Rezoning Transportation Analysis

Petition Number: 2023-043

From: Jake Carpenter, PE
Jacob.carpenter@charlottenc.gov
980-221-5675

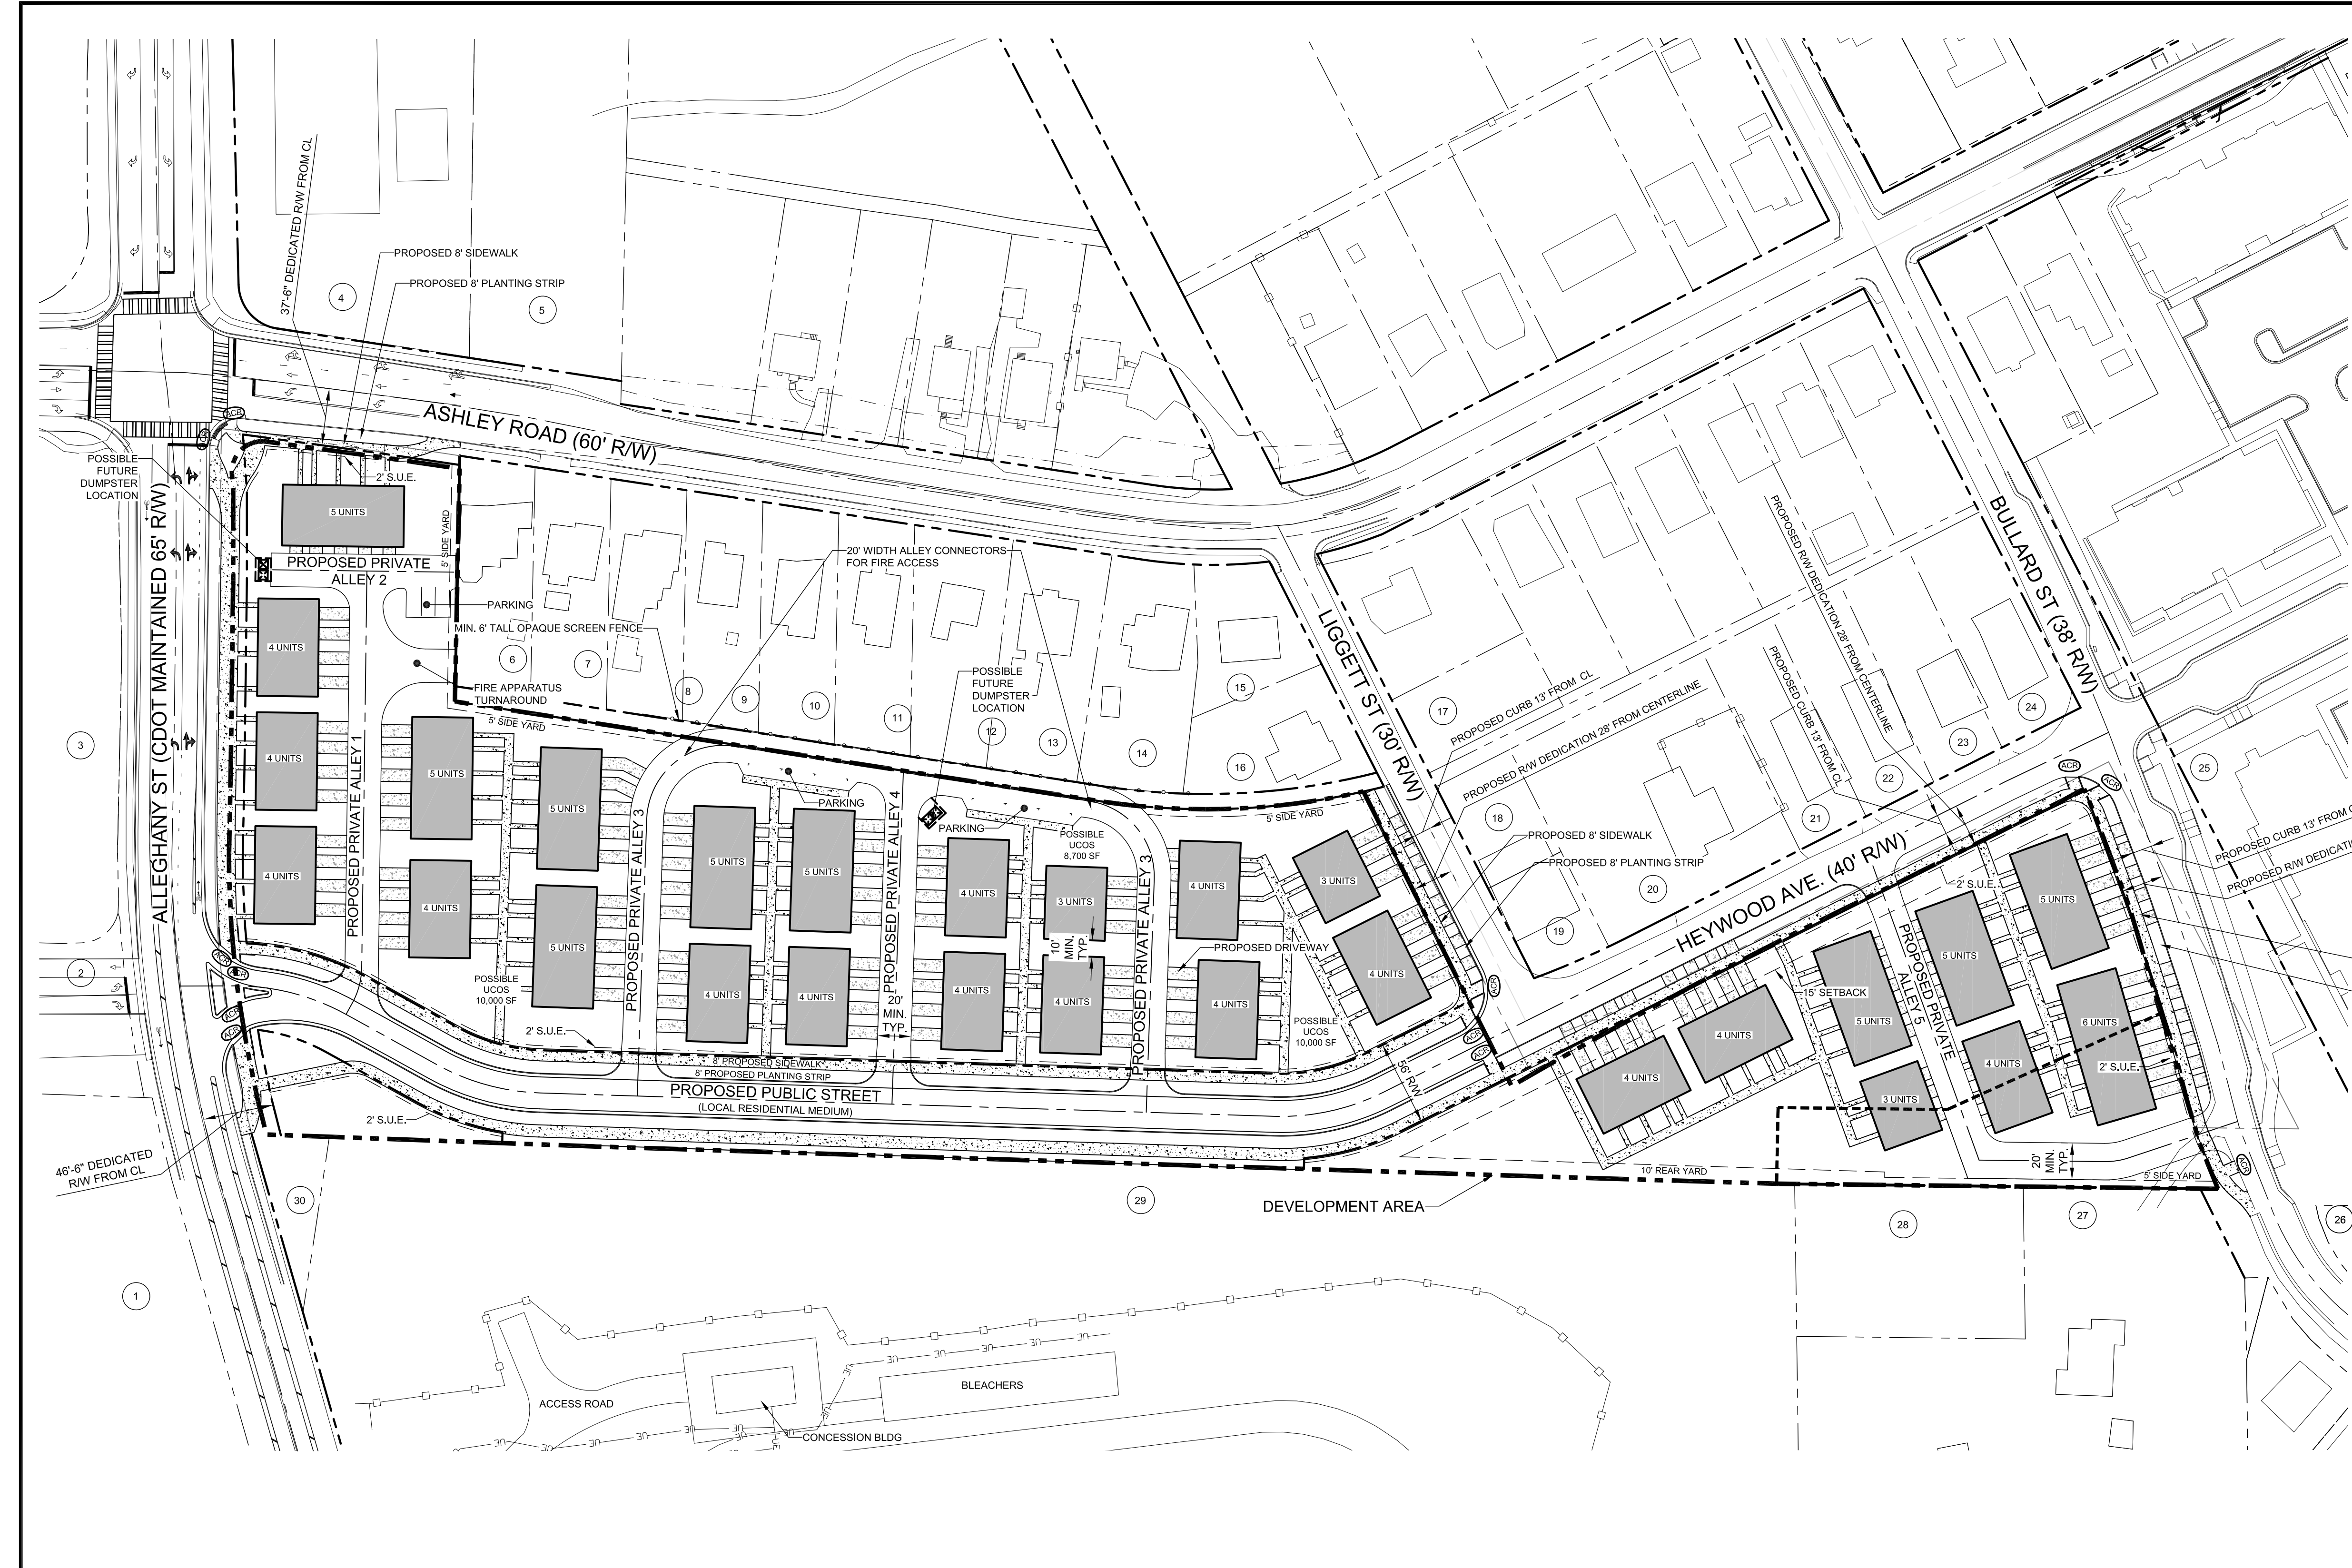
1. Curblines:

- a. **Proposed Public Street A:** New local residential medium street, back of curb located 13' from the centerline.
- b. **Alleghany Street:** Future back of curb located 27' from the centerline to accommodate a roadway cross section of a 2+lane avenue with buffered bike lanes.
- c. **Ashley Road:** Future back of curb located 21.5' from the centerline to accommodate a 2 lane avenue with buffered bike lanes.

Label and dimension the curb and gutter from the centerline for each road on the site plan.

6. Revise site plan and conditional note(s) to remove the fence completely from the public alley and onto private property. If fence is to remain along the single family home side it needs to be completely on private property.
